**MAJOR PROJECT ASSESSMENT:  
7-9 Gibbons Street, Redfern  
(MP08\_0112 MOD3)**

Director-General's  
Environmental Assessment Report  
Section 75W of the  
*Environmental Planning and Assessment Act 1979*

November 2012

SURVEYOR: JOHN WALTON
DATE OF SURVEY: 12 MARCH 2012
SURVEYOR's REF: 1200-10DP

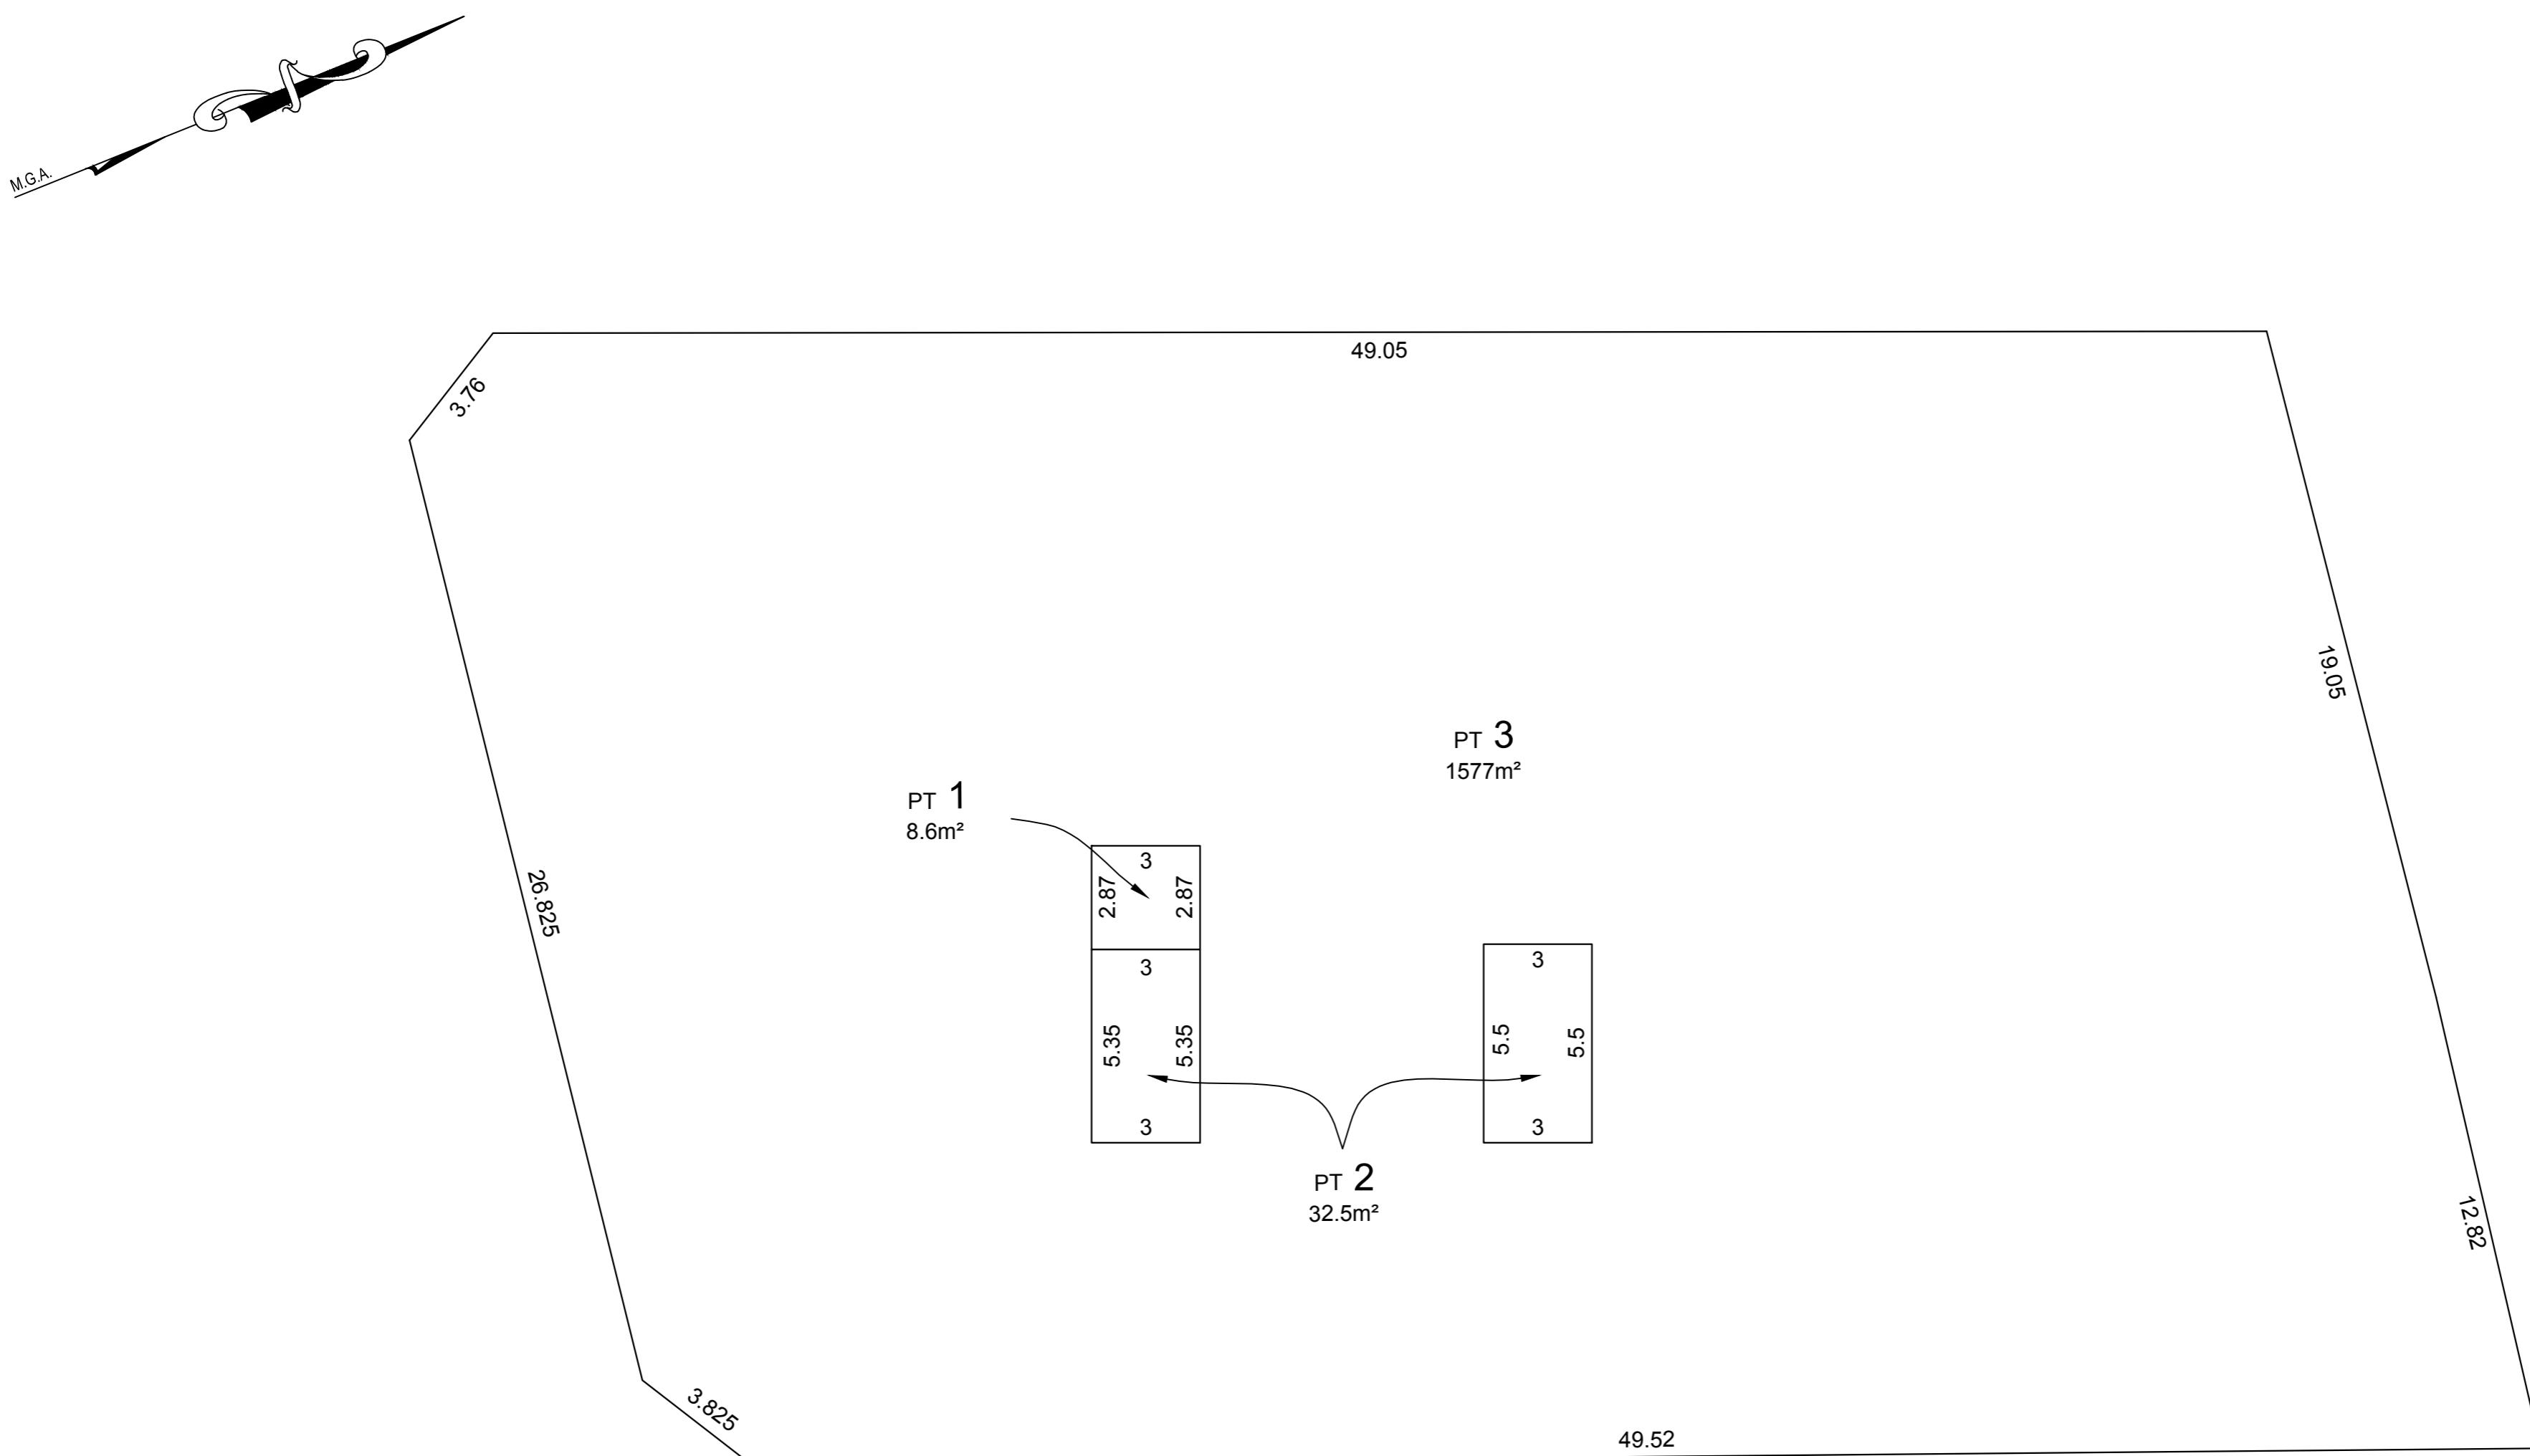
The modification request includes a draft stratum subdivision plan for the following allotments:

The Department considers the stratum subdivision to be consistent with the project approval and raises no issues in this regard. It is further noted that the draft stratum plan is generally consistent with the parking provision requirements contained in Condition A10 of the project approval. Although the specific number of car parking spaces allocated for each stratum lot have not been specifically nominated, the stratum subdivision does not preclude the requirement of the proposal to provide the car parking numbers listed in Condition A10. Therefore, the Department maintains confidence that the required number of car parking spaces will be provided.
